**Re: 38 Morse Street (32-38 Morse Street); Addition of 2-units
AMENDMENT**

**Re: Application ID: # 2008-0064
Original Site Plan Approval dated September 28, 2009
CBL: 163 A015 001 and 163A A016 001**

To: Barbara Barhydt
Jean Fraser
From: David Margolis-Pineo
Public Services Review Comments
Re: 38 Morse Street

1 TYPICAL UTILITY PIPE TRENCH SECTION
NOT TO SCALE

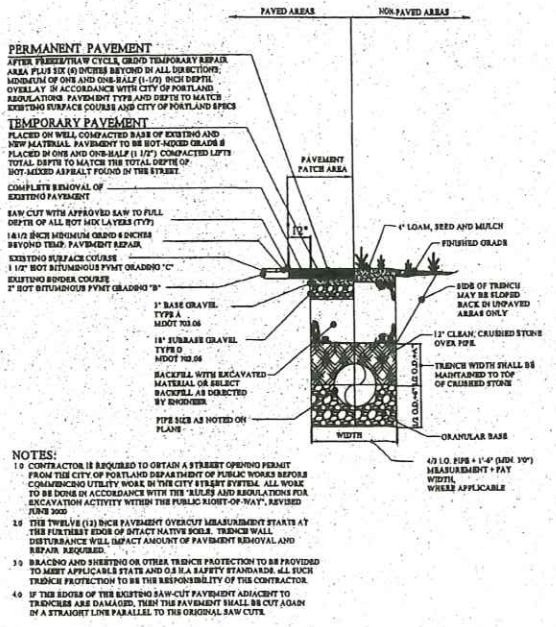
1. The applicant's site plan currently shows granular bedding under the sewer pipe to be installed in the street. This detail is incorrect. Please use the following details for utility bedding and street repair when excavation with the Morse Street right of way. Thank you.

- i. That the applicant shall use the details provided in the Public Services Memorandum dated March 3, 2010 (attached) for utility bedding and street repair when excavating within the Morse Street right of way; and

5 CONCRETE CATCH BASIN DETAIL
NOT TO SCALE

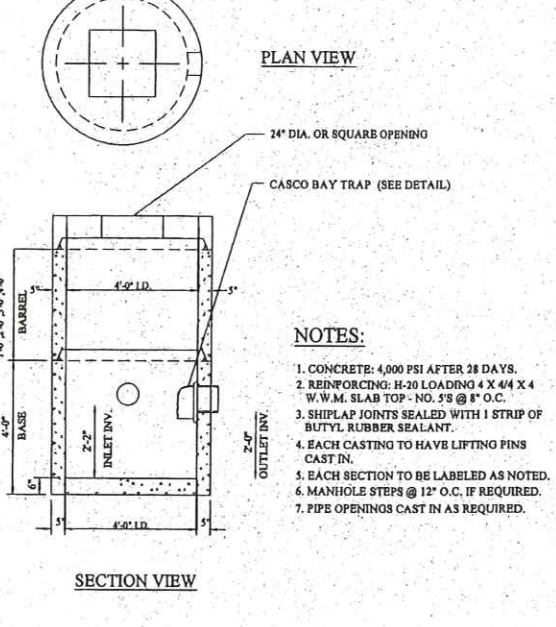
- Portland City standards require all catchbasins connected to the City's sewer system to have three foot sumps. The applicant is asked to install a three foot sump in the proposed catchbasin.

- ii. The applicant shall install a three foot sump in the proposed catchbasin; and
- iii. That if the construction of the project is phased, the first new unit shall meet all site plan requirements (landscaping, fencing, and drainage/infrastructure) prior to the issuance of a Certificate of Occupancy (CO); and
